Angmering Parish Council

5 December 2014

OBJECTION by Angmering Parish Council to planning application A/154/14/OUT "Outline Application for the erection of 18 No. dwellings"

SITE PLAN

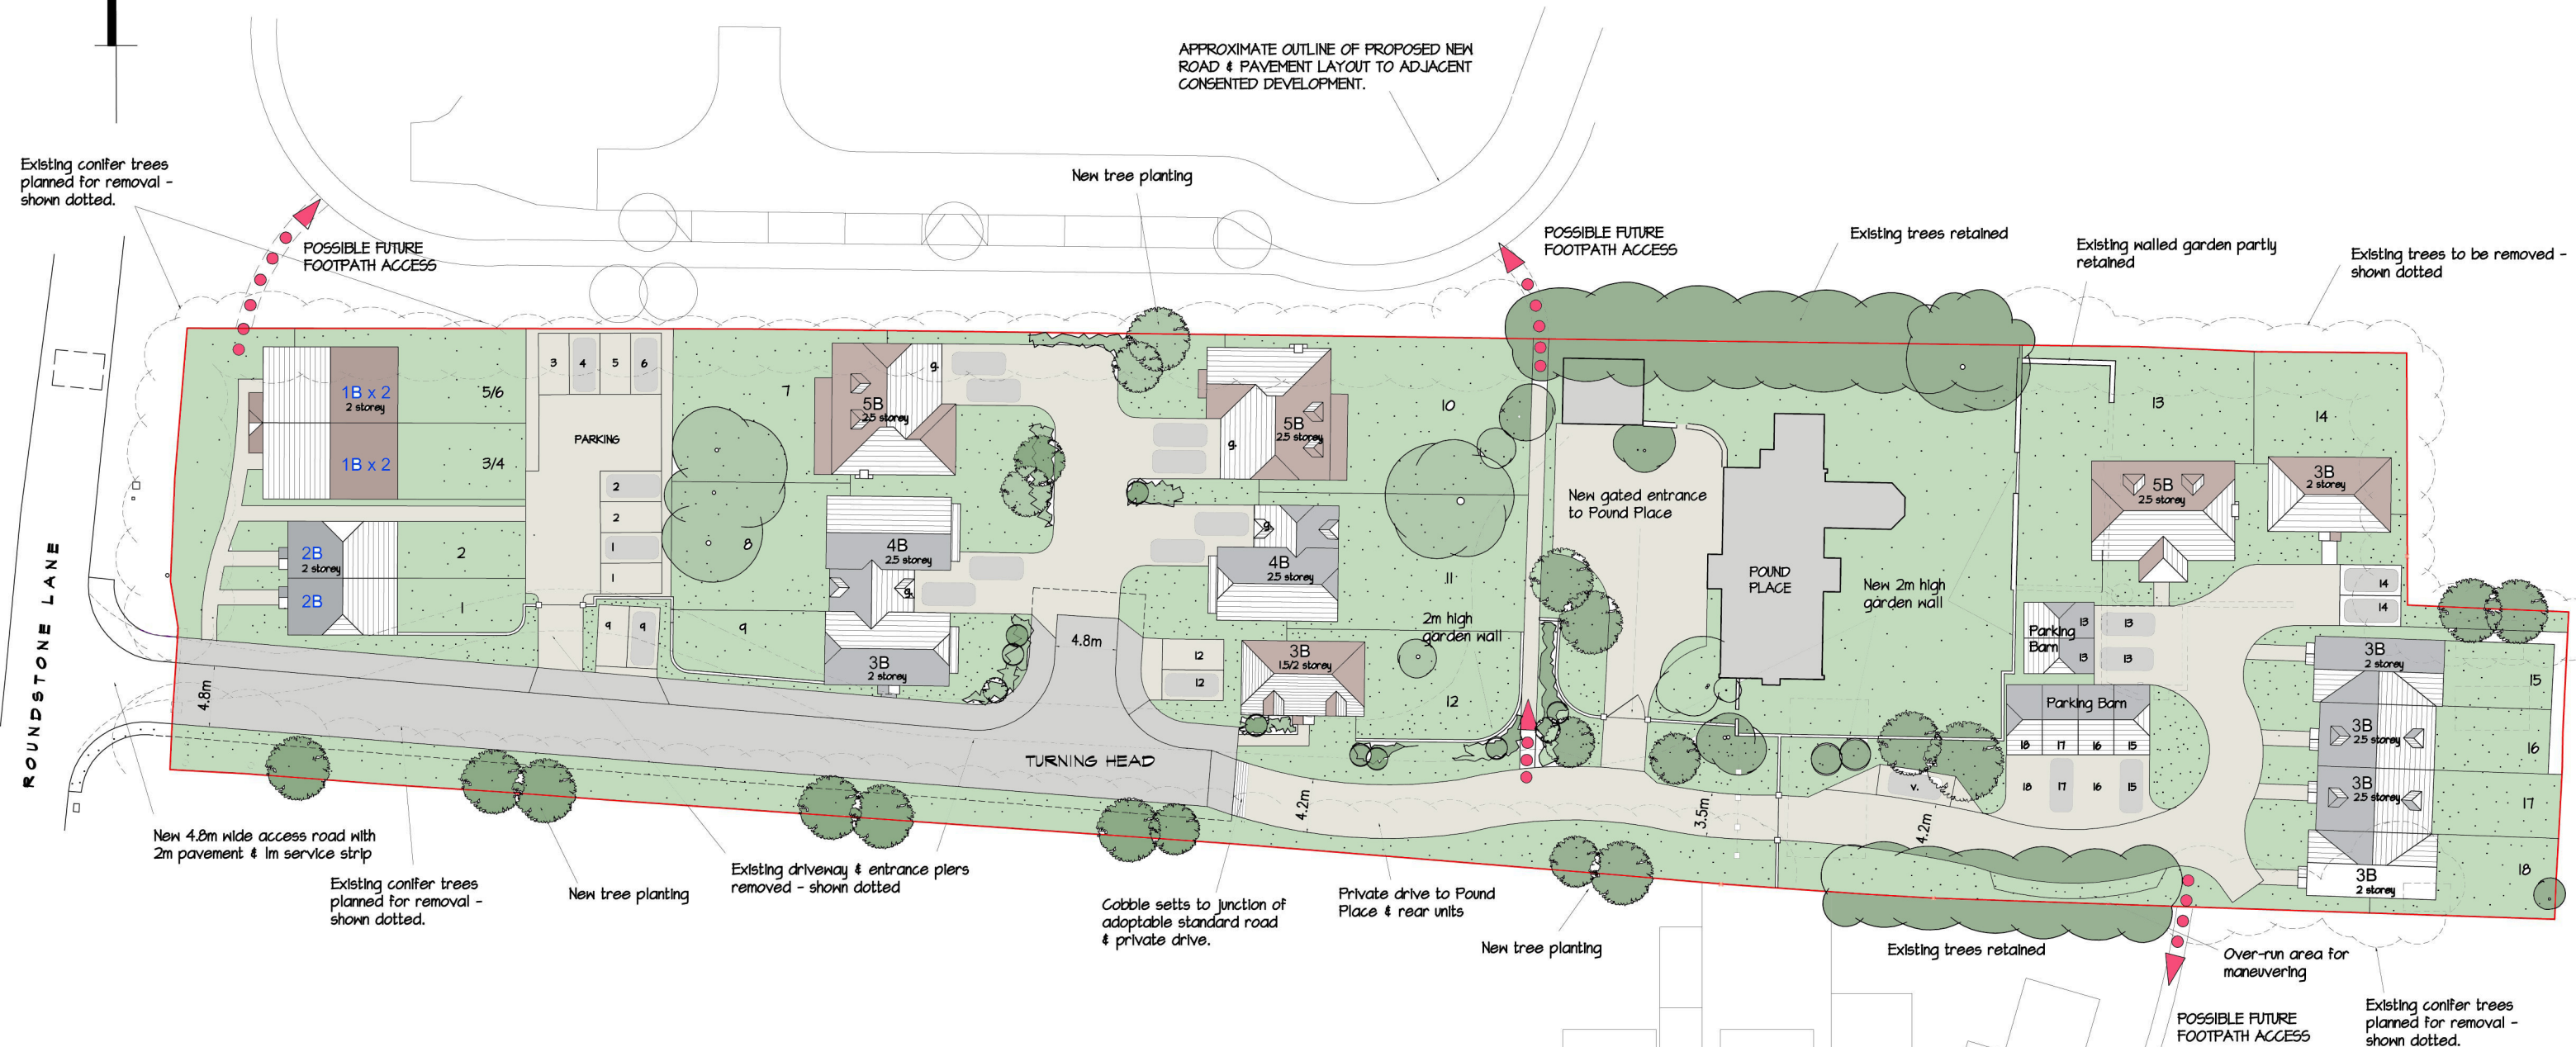
The addition of 18 further dwellings in addition to the existing residential property on the subject site is an overdevelopment of the plot. In addition, given the proposed numbers of dwellings for which planning permission has already been granted on neighbouring sites, the Parish Council is not persuaded that there is any need for the development contemplated in this application.
